Remodelling & extensions
Hascombe 33 Tamarisk Way East Preston

Thank you for your internet representation made on 19th October 2015 which has been recorded as '**an objection**' with the comments as follows:

First Floor Plan

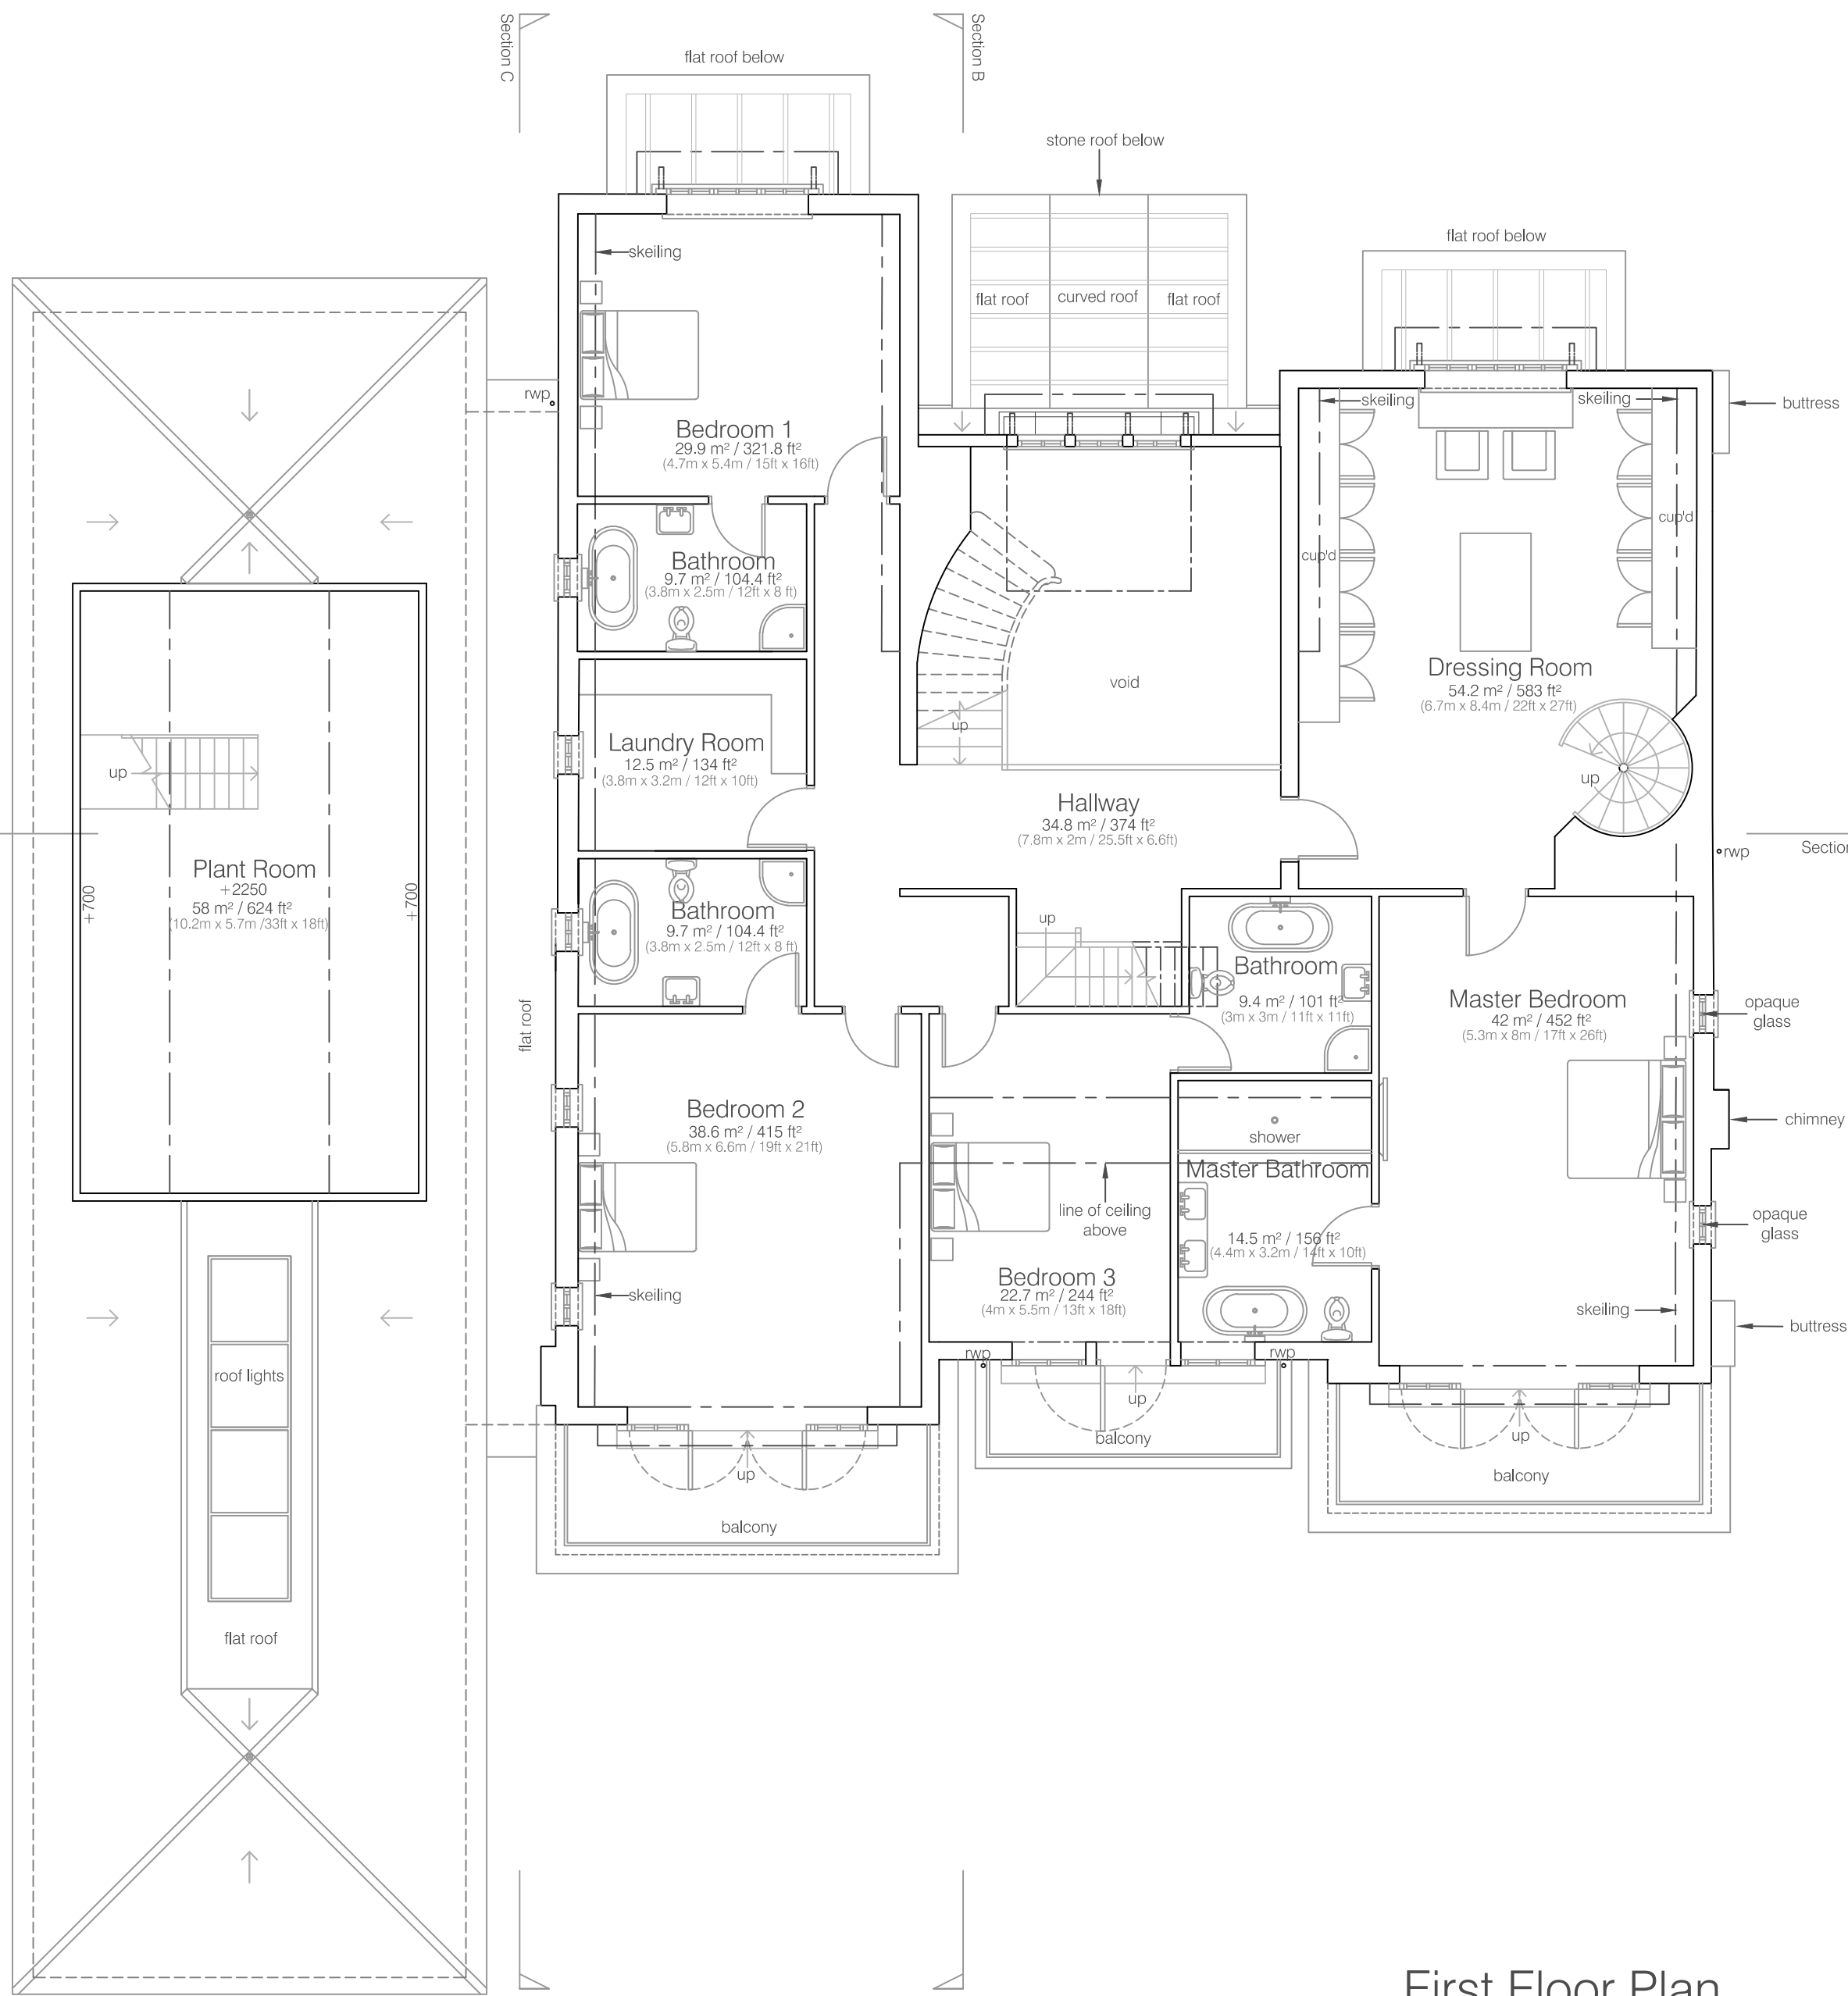
I feel the scale, form and location of the proposed development would be totally out of character with the other houses in Tamarisk Way. The length of the new building along the adjoining footpath would be an eyesore to all that enjoy the Greensward. The first floor extension would cause a loss of light and amenity to the neighbouring property and would be over looked by the proposed windows. I feel the proposed first floor extension should be greatly reduced and the size of the swimming pool area along the footpath should be reduced in length.
